# **Green Hill Solar Farm**

### **Appendix 8.5: Landscape Consultation**

## Appendix 8.5 LVIA Consultation Record

Figure 4.22 Indicative Permissive Paths

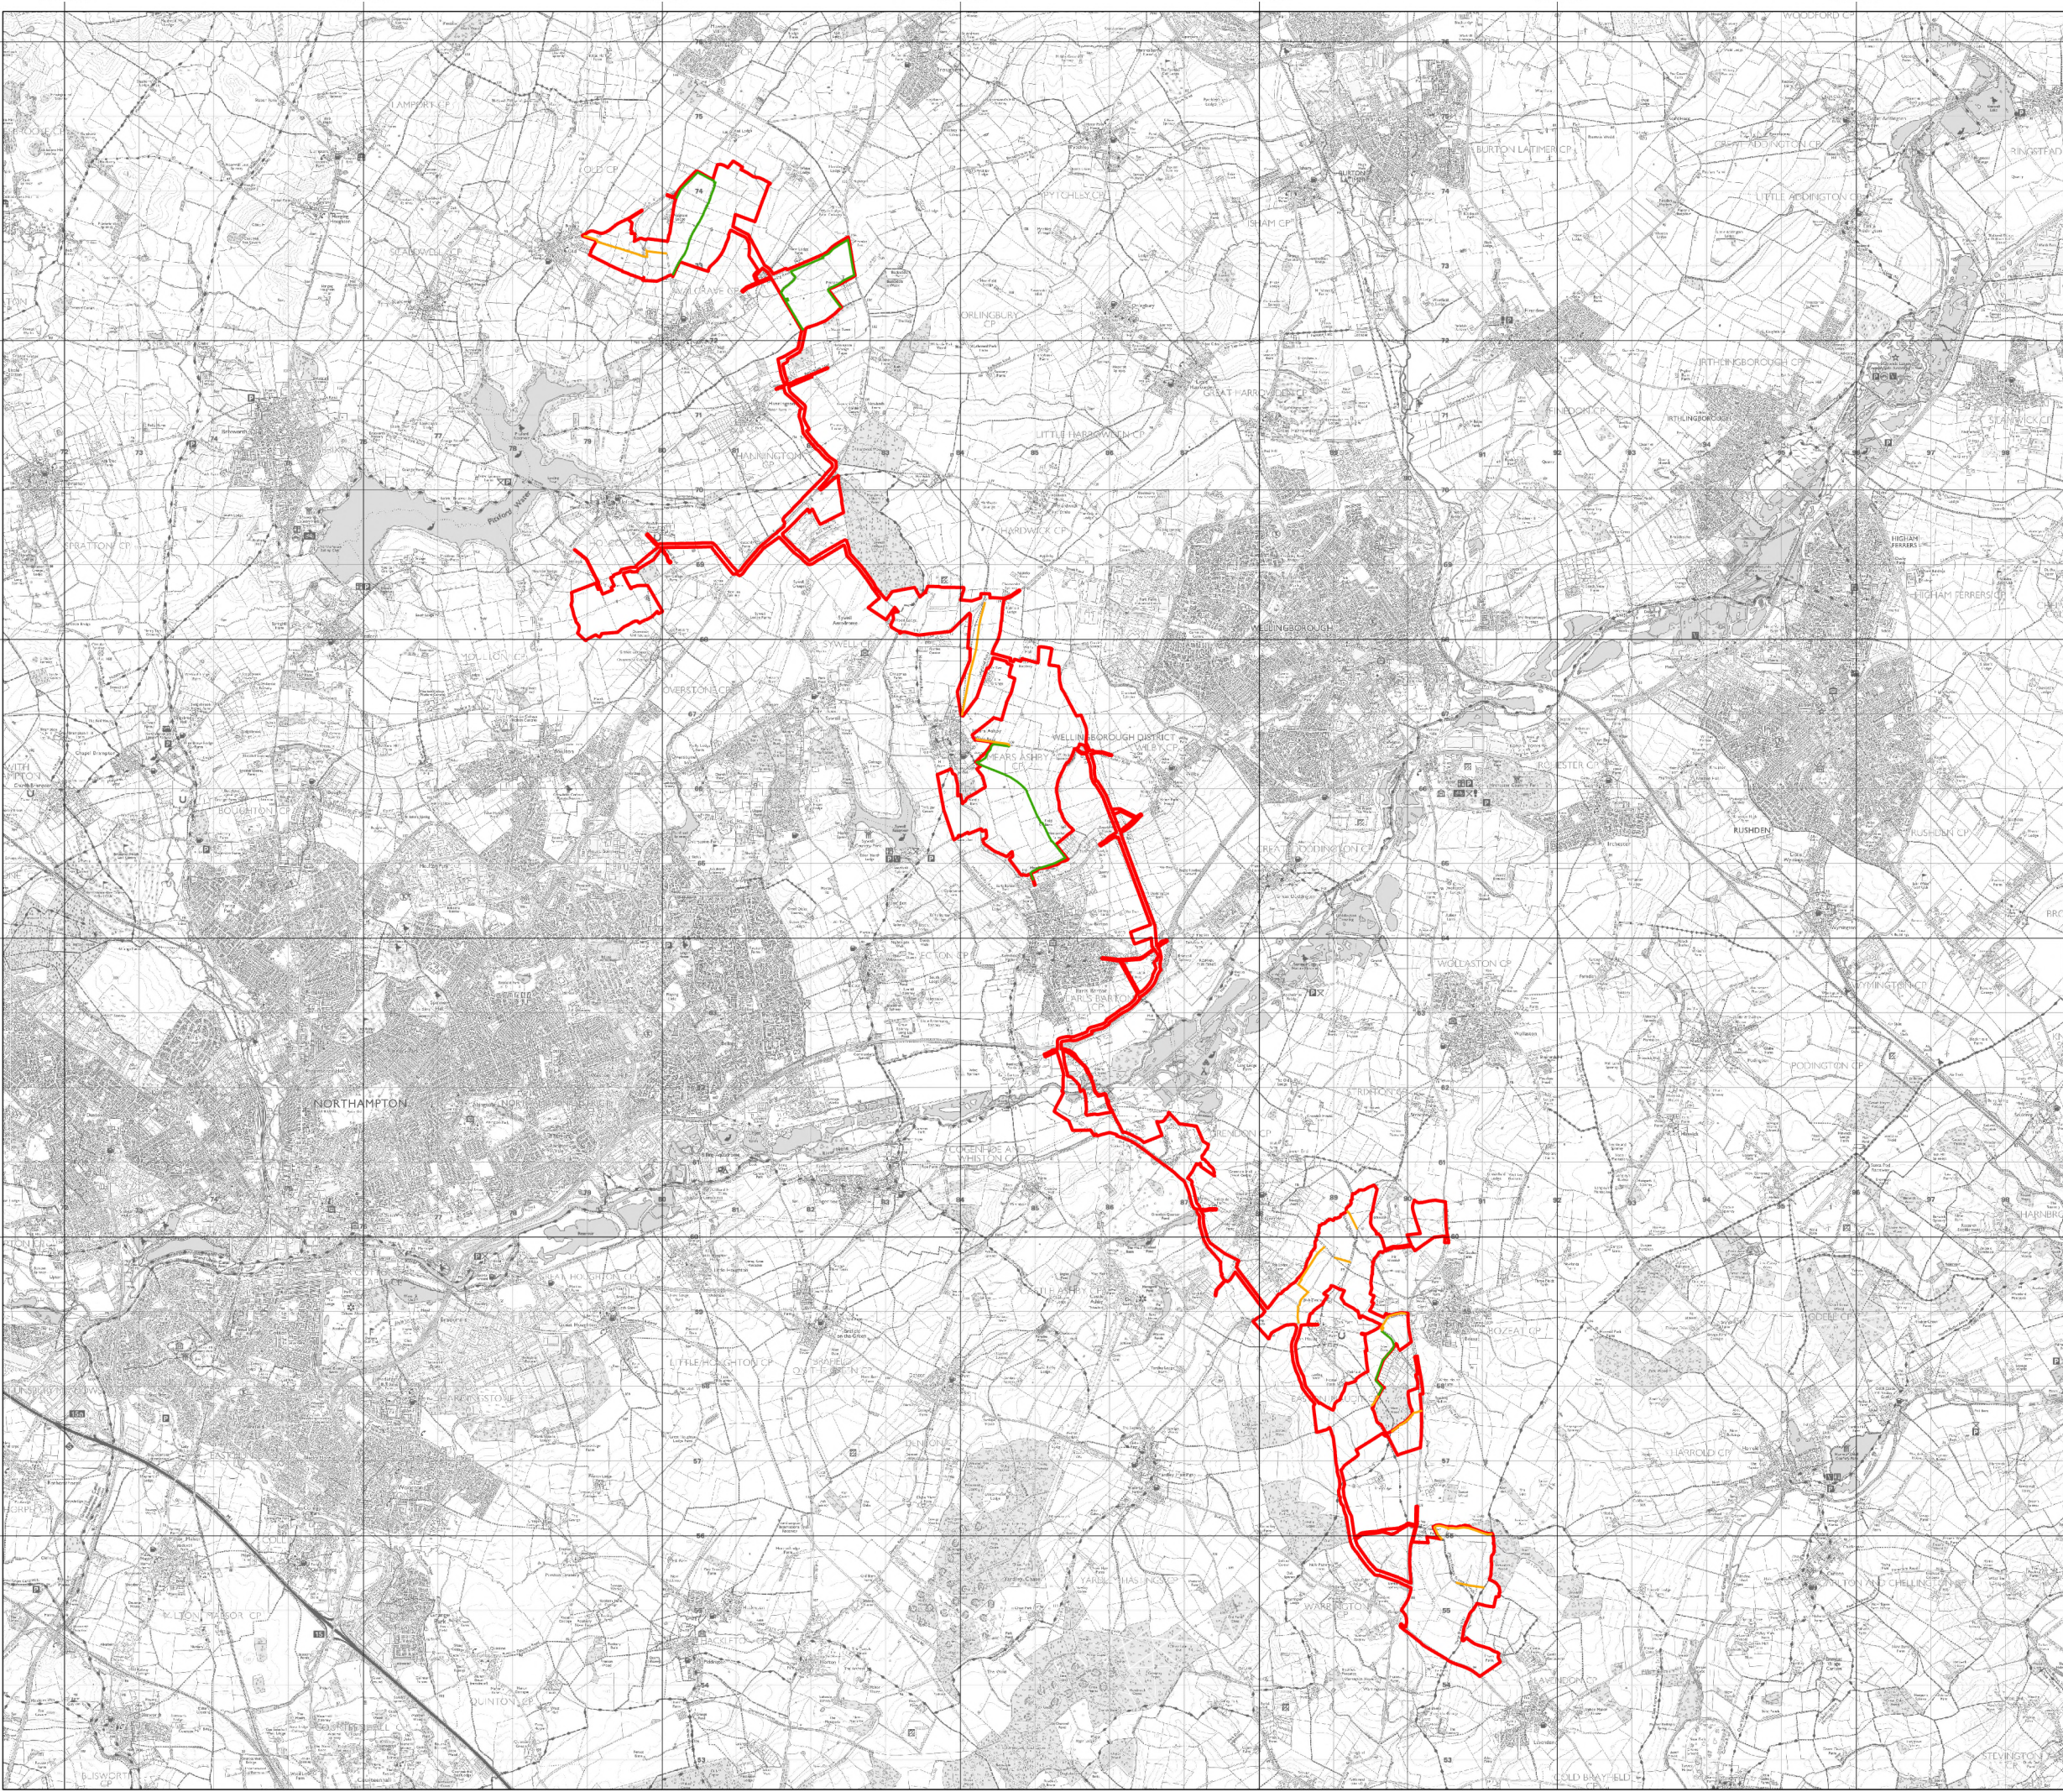
North Northamptonshire	6.27 NNC landscape consultant recommend that additional permissive footpaths to the east of Mears Ashby are provided, creating connections between areas to the north and south of the development area. This would enhance recreational opportunities while improving accessibility for local communities.	Permissive Paths on Site E have been discussed with NNC and added to the Landscape and Ecology Mitigation Plans.
North Northamptonshire	6.28 Though the supporting evidence for judgements refer to winter views, the PEIR is supported by summer photography. The omission of a full winter assessment could mean the adverse visual effects are understated, particularly for receptors within 1 kilometre, residential receptors close to the Sites, such as properties in Mears Ashby, Grendon, Easton Maudit, PROWs and transport corridors with views of open fields, especially near Sites E and F.	Had a follow up meeting with NN (23/01/2025) where winter photography was agreed.
